**WEST SUSSEX COUNTY COUNCIL
STRATEGIC PLANNING CONSULTATION**

DATE: 03/03/2015

SUBJECT: Y/12/15/PL- Construction of 4 no houses with associated landscaping and parking.

The Old Coal Yard, North End Road, Yapton, BN18 0DN

Proposed Access
Arrangement

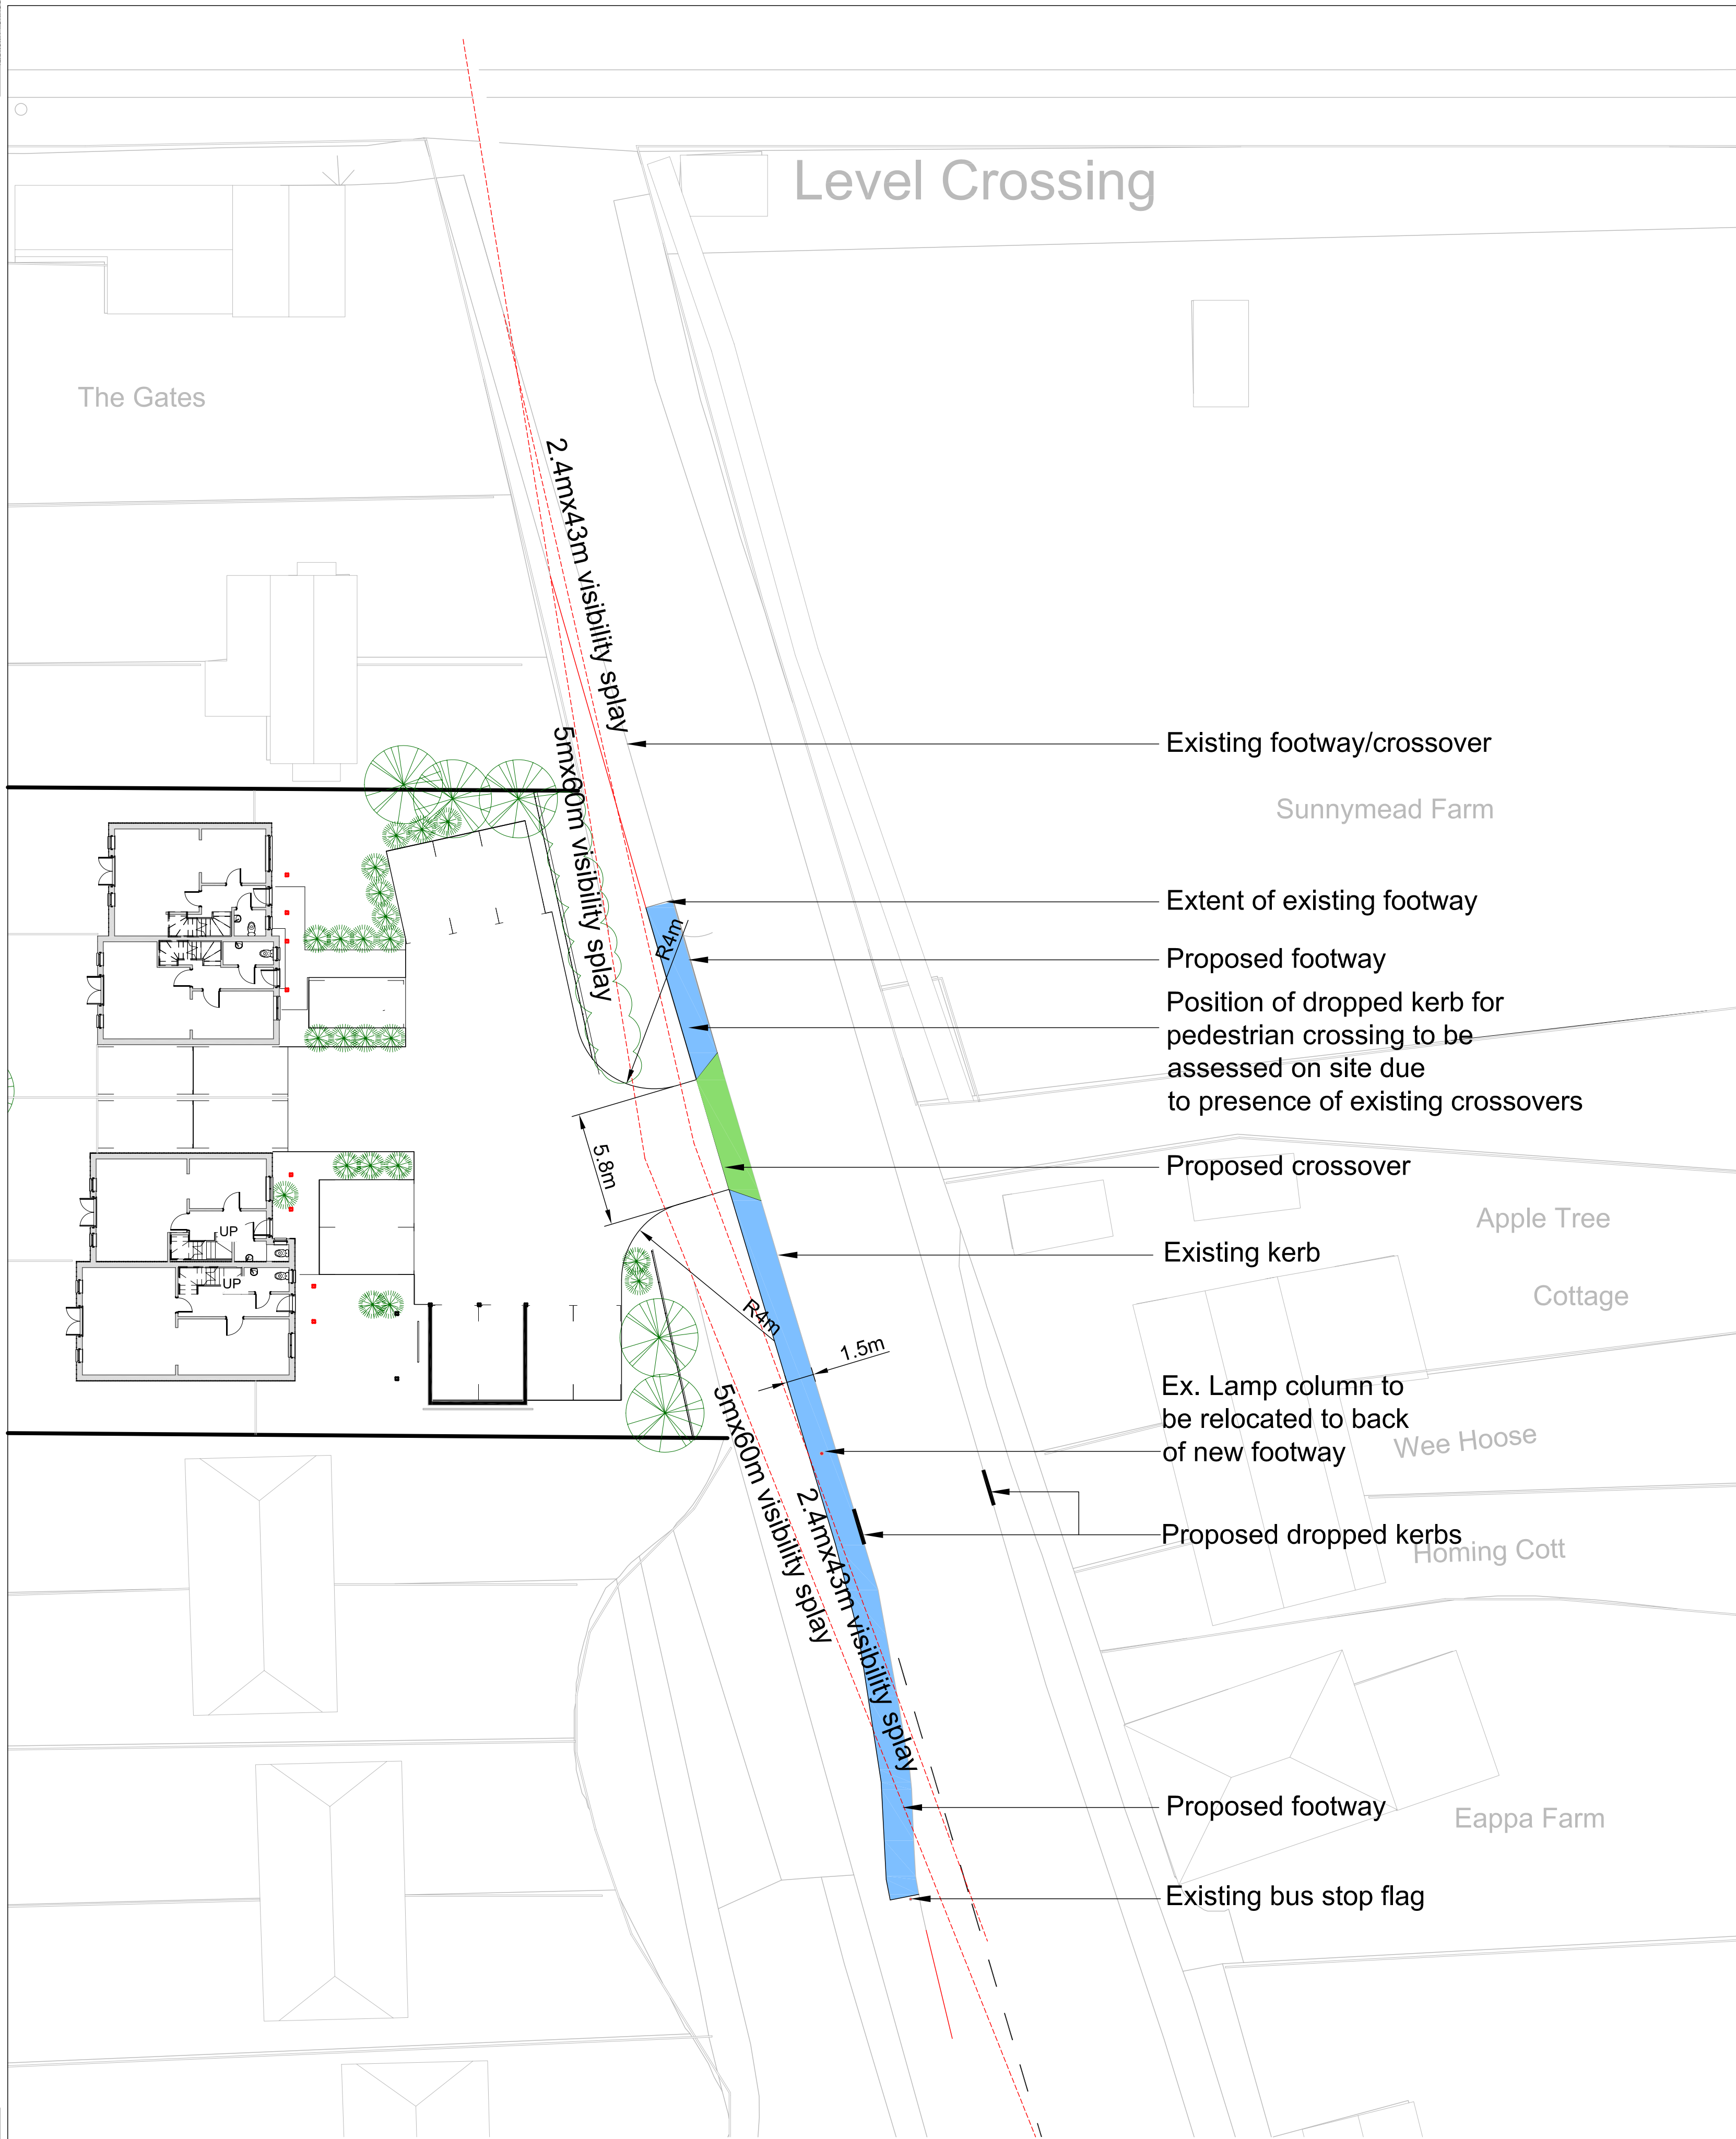
The proposal is as described above. A new access will be required onto North End Road; the proposed visibility splays, taken from a setback of 2.4m, extend 43m to a point on the nearside kerb line and this is consistent with Manual for Streets (MfS) guidance. MfS does

provide some allowance for occasional on-street parking within the visibility splay and it would appear that in this area, where most properties have some sort of off-street parking facility, that there is not an extensive demand for on-street parking particularly during peak movement time.

Given the shared usage of this access point a 4.5 metre crossover would be required the site plan shows that this widens to 5.8 metres. The works on the highway for the new access must be agreed with the WSCC Local Engineer and carried out under licence. I would also require the driveway area and car parking spaces to be constructed in a bound material and that suitable drainage methods are installed to prevent private surface running onto the public highway.

If the LPA are minded to approve this application a condition securing visibility spays for vehicles, car parking and cycle parking should be included.
